KITITITAS COUNTY

DEPARTMENT OF PUBLIC WORKS

MEMORANDUM

TO: All Staff
FROM: Public Works Planning Review Team
DATE: December 29, 2020
SUBJECT: SPF-20-00002 Dunford (Resubmitted Dec 2020)

DWN BY	DATE	JOB NO.
D.L.P./G.W.	1/2021	08010
CHKD BY	SCALE	SHEET
D.L.P.	1" = 200'	4 OF 6

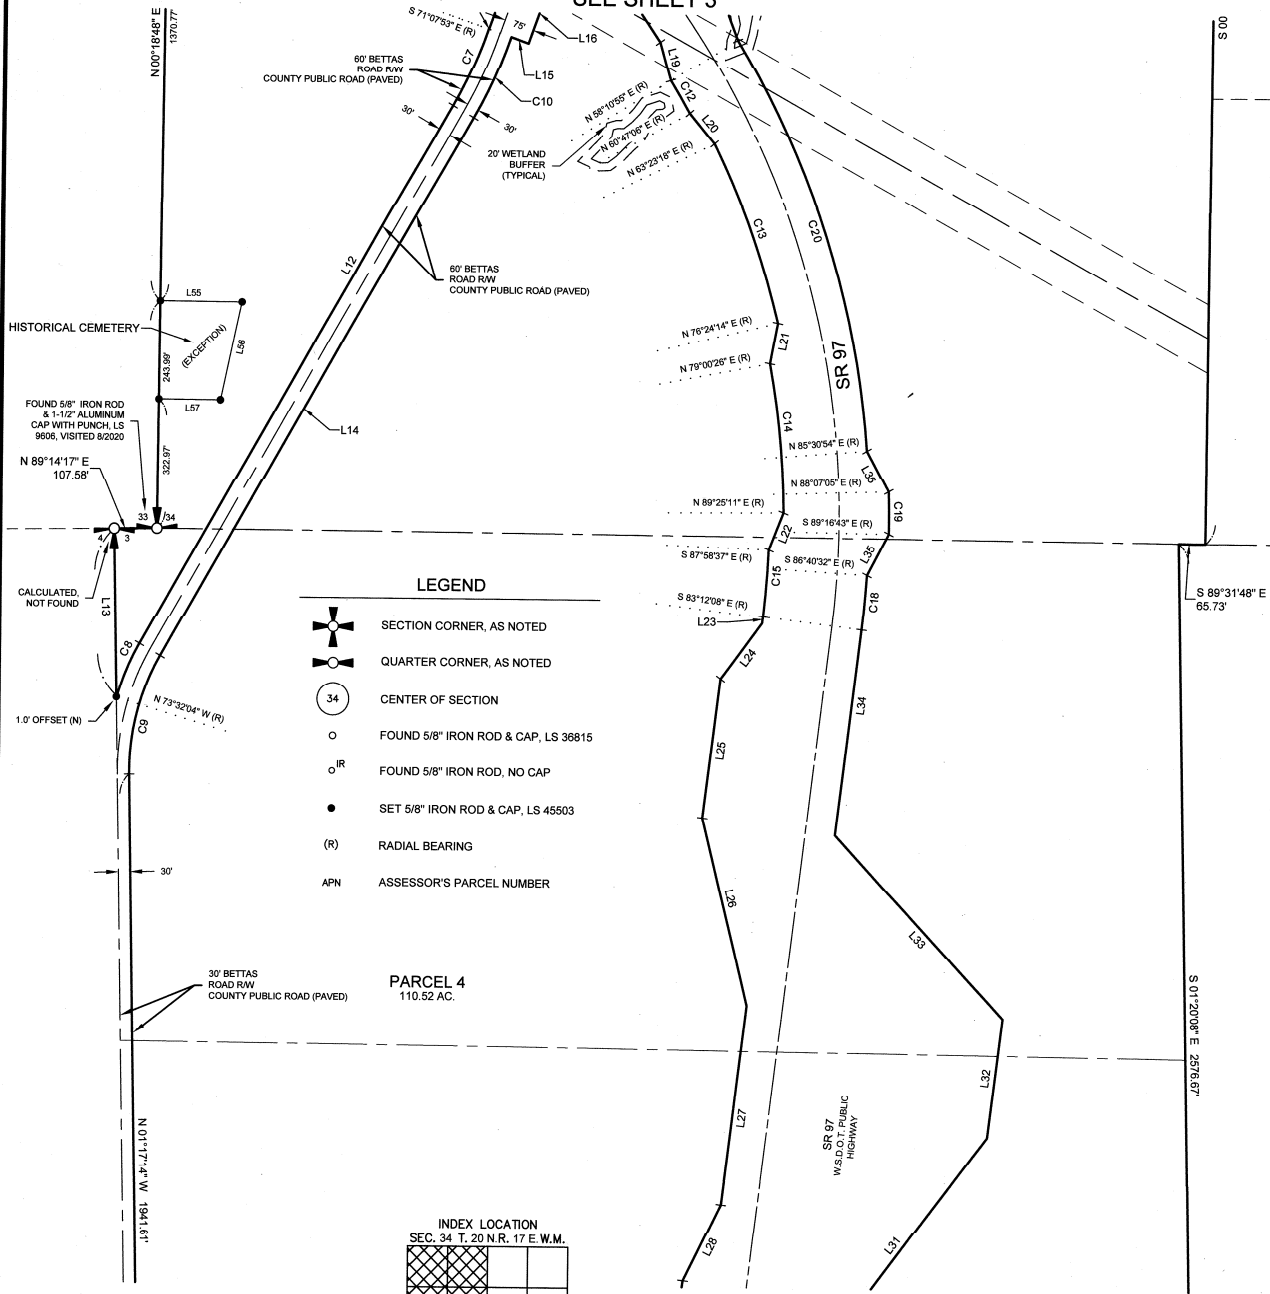
1. Auditor's Certificate missing.
2. The inclusion of Tract CY-1 brings the total number of lots to 5, which would result in a Long Plat requirements. The notation as "Exception" on sheet 4 does not exclude this from being a unique parcel, adding to the total lot count.
